**WIDEFIELD WATER AND
SANITATION DISTRICT**

2 MG ROLLING HILLS TANK

**SITE DEVELOPMENT PLAN
DRAINAGE LETTER**

**RE: Widefield Water and Sanitation District
2 MG Potable Water Tank
1041 Submittal – Drainage Letter
Address: TBD (Schedule 5500000385)**

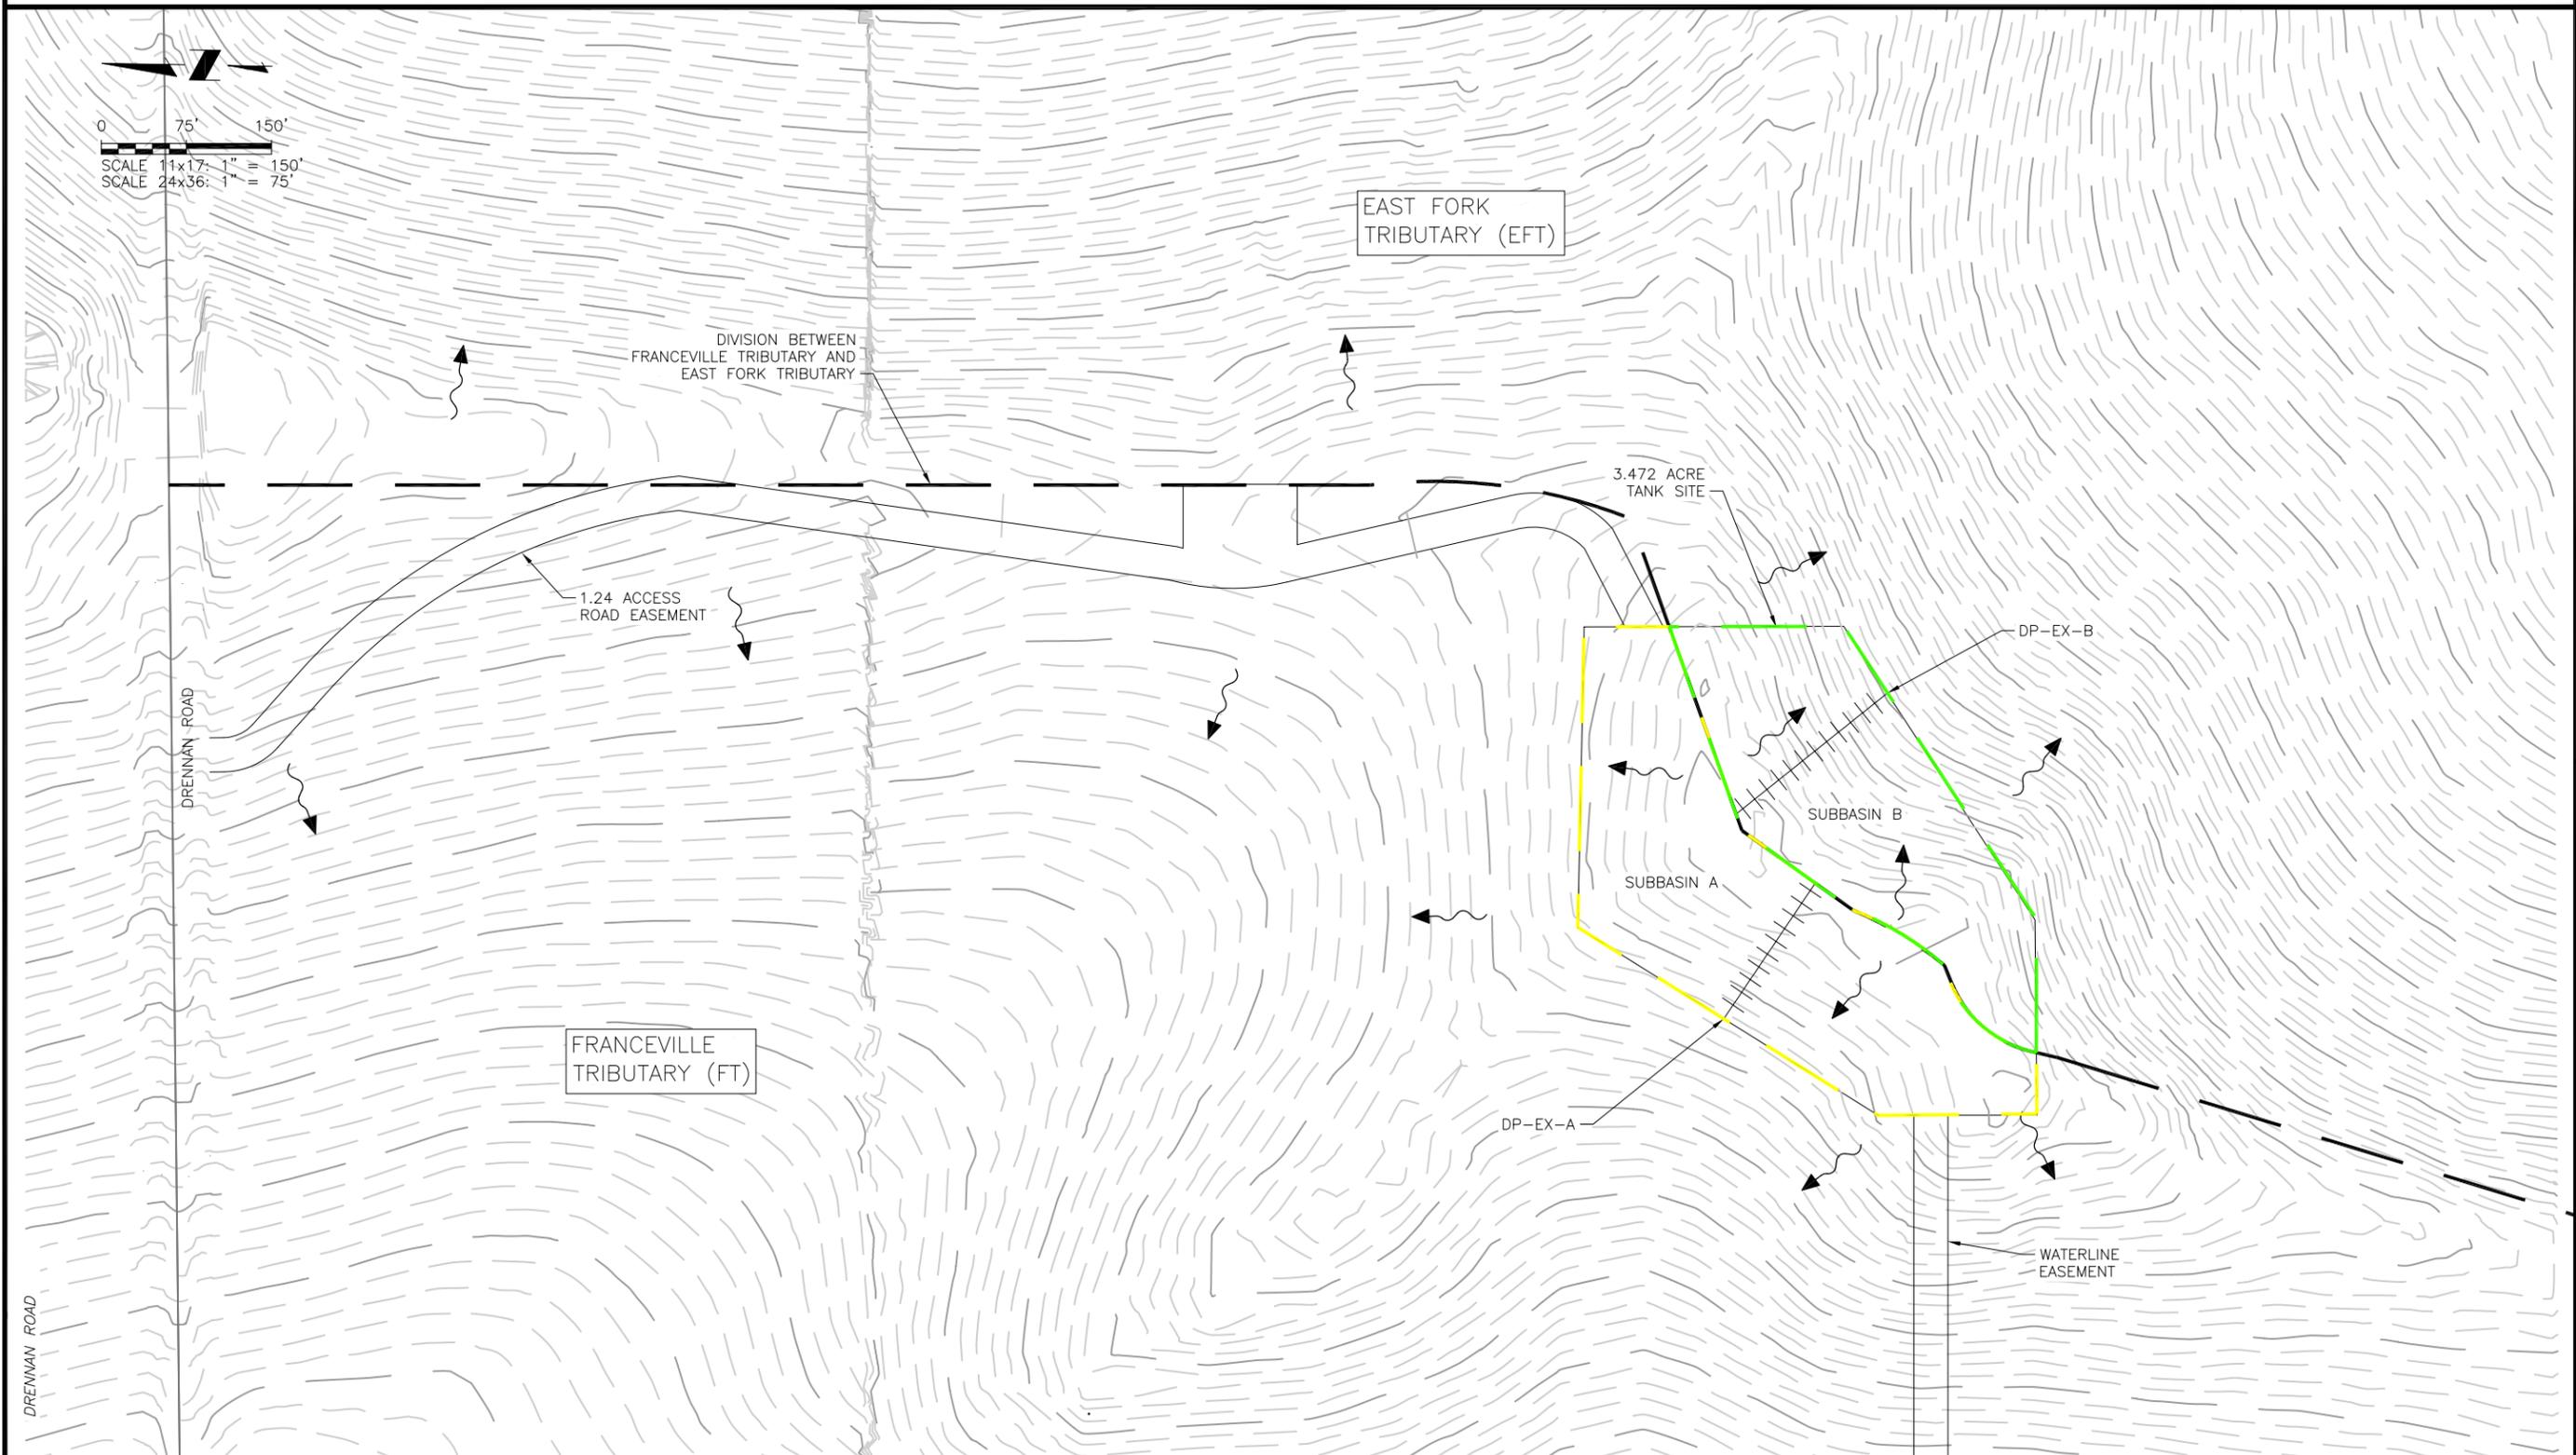
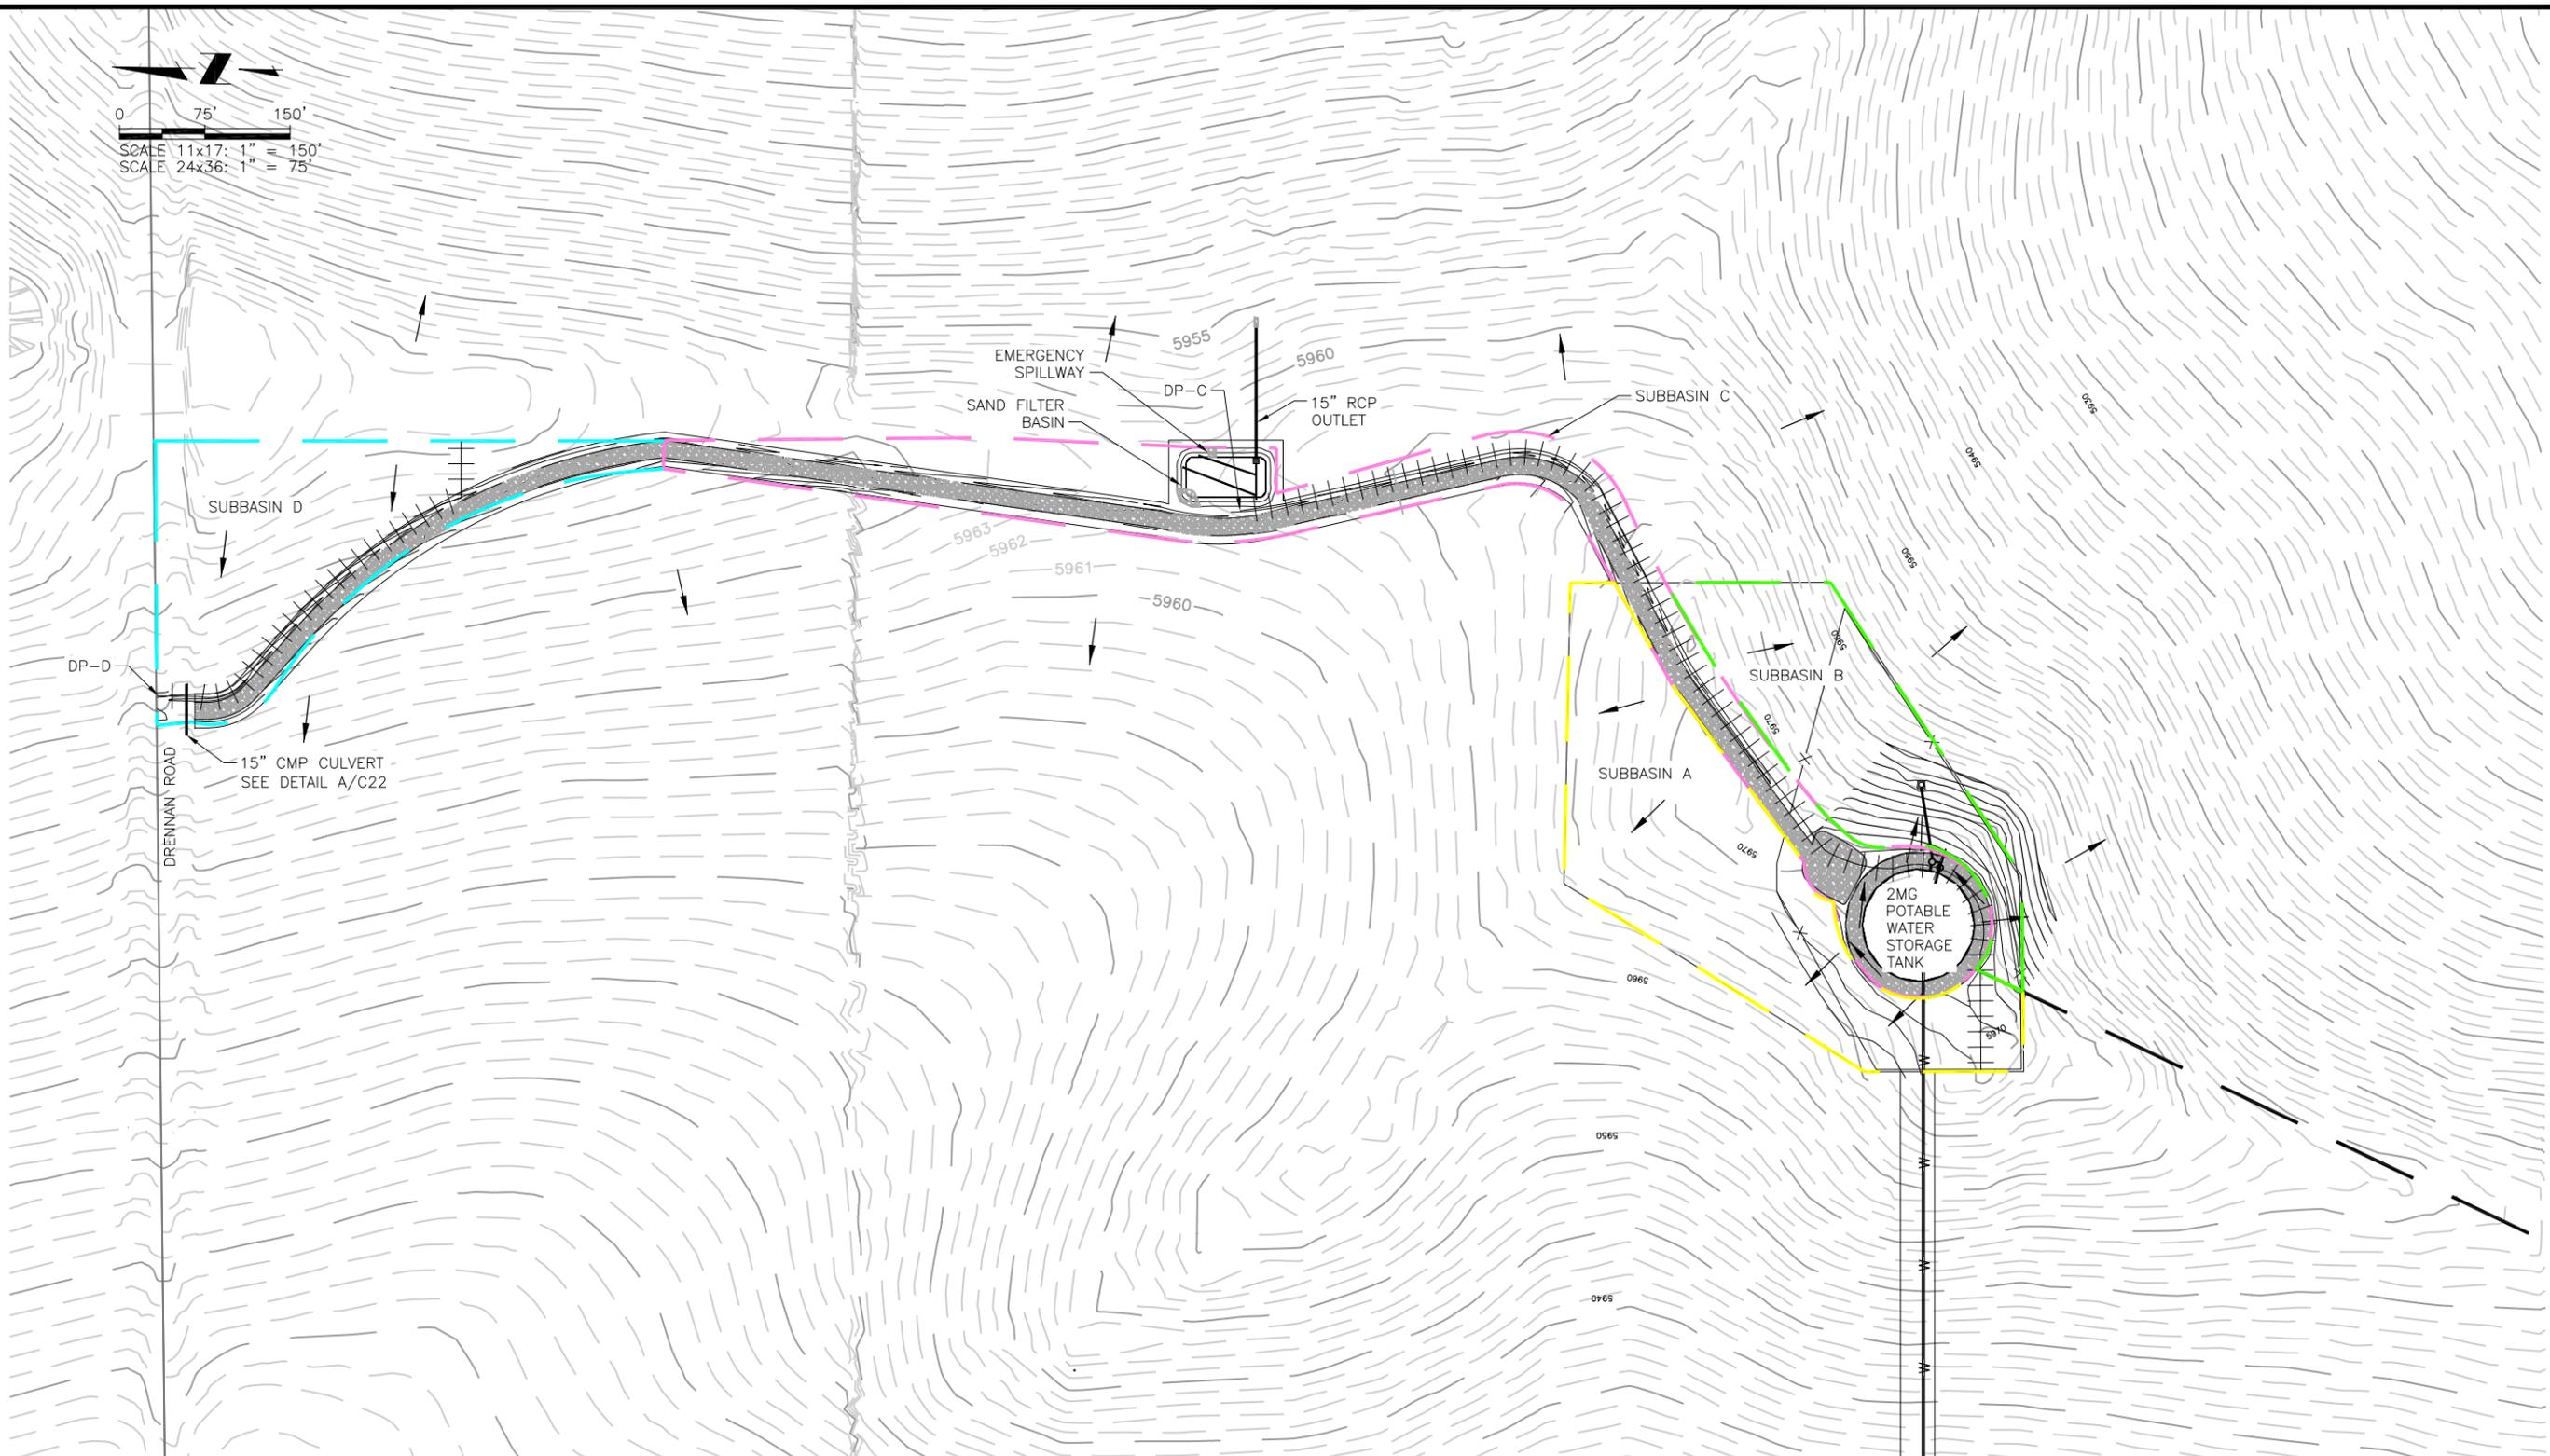
C? that is where the SFB is.

**B** OUTLET STRUCTURE  
C21 SCALE: 3/8" = 1'-0"

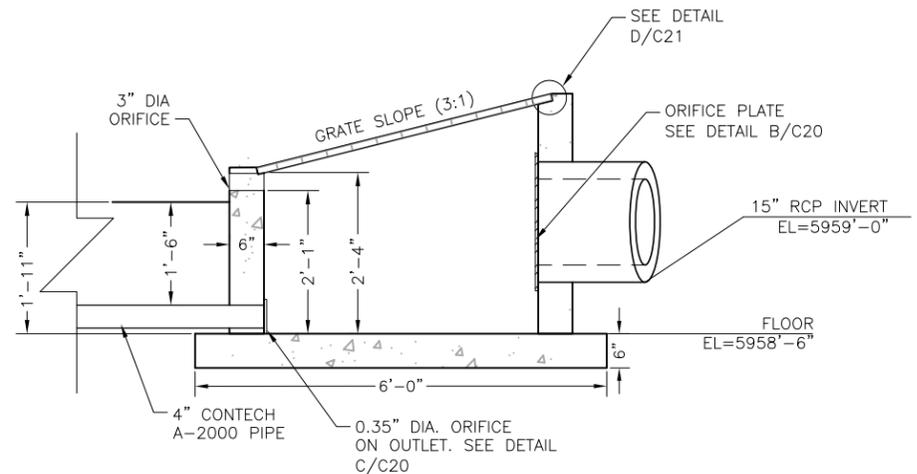
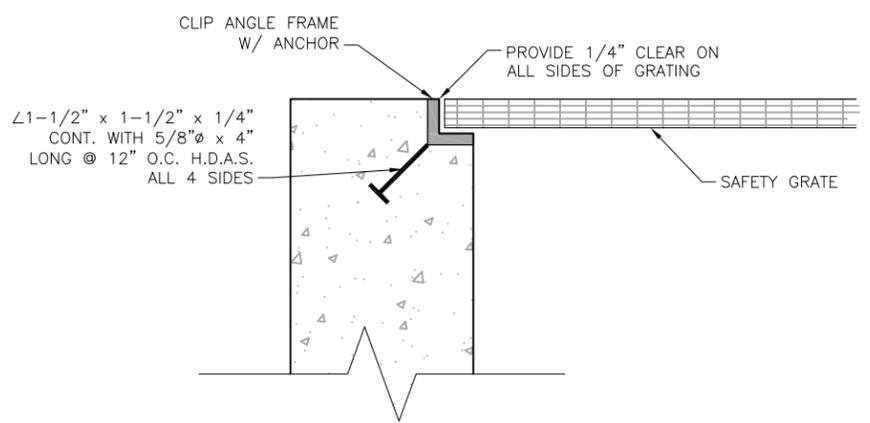
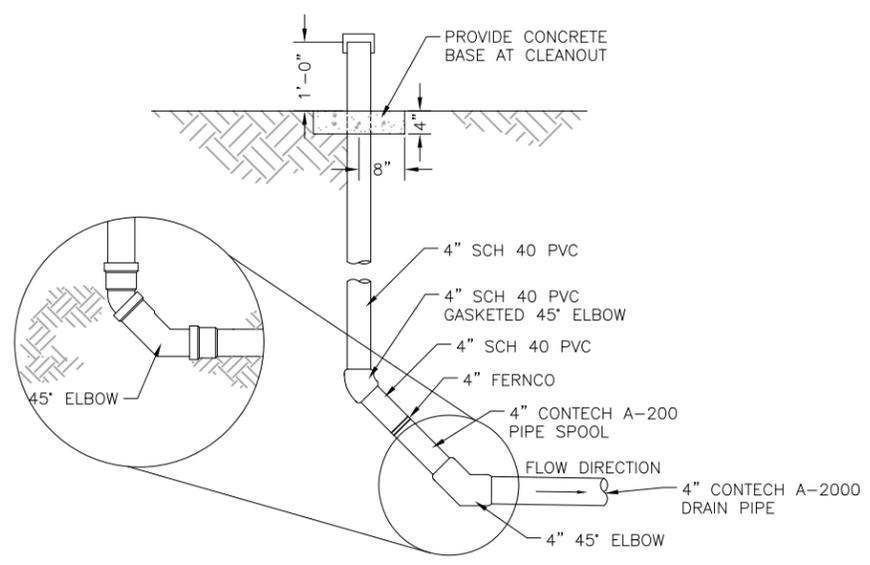
Please add to the table the flows after being detained (release rate) in the SFB.
